Order Granting Development Consent for Tween Bridge Solar Farm at Land either side of the M180, High Level Banks (the A18) and the Stainforth and Keadby Canal (EN010148)

Deadline 3: Representations on further information submitted at Deadline 2

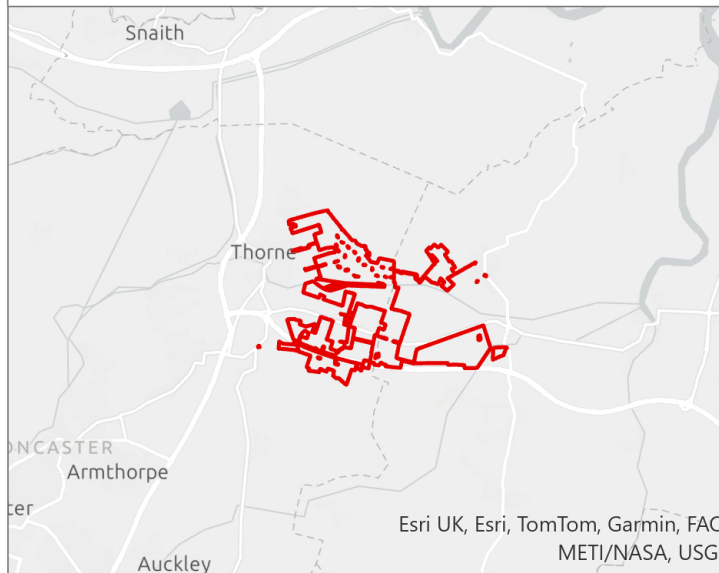
4.4 We note that the proposed culverting of the North Soak Drain does not appear to be shown on the Indicative Culvert Crossings Plan [[APP-138](#)]. If the Applicant cannot find a reasonable alternative to culverting the North Soak Drain then this plan should be updated to include its intended location.
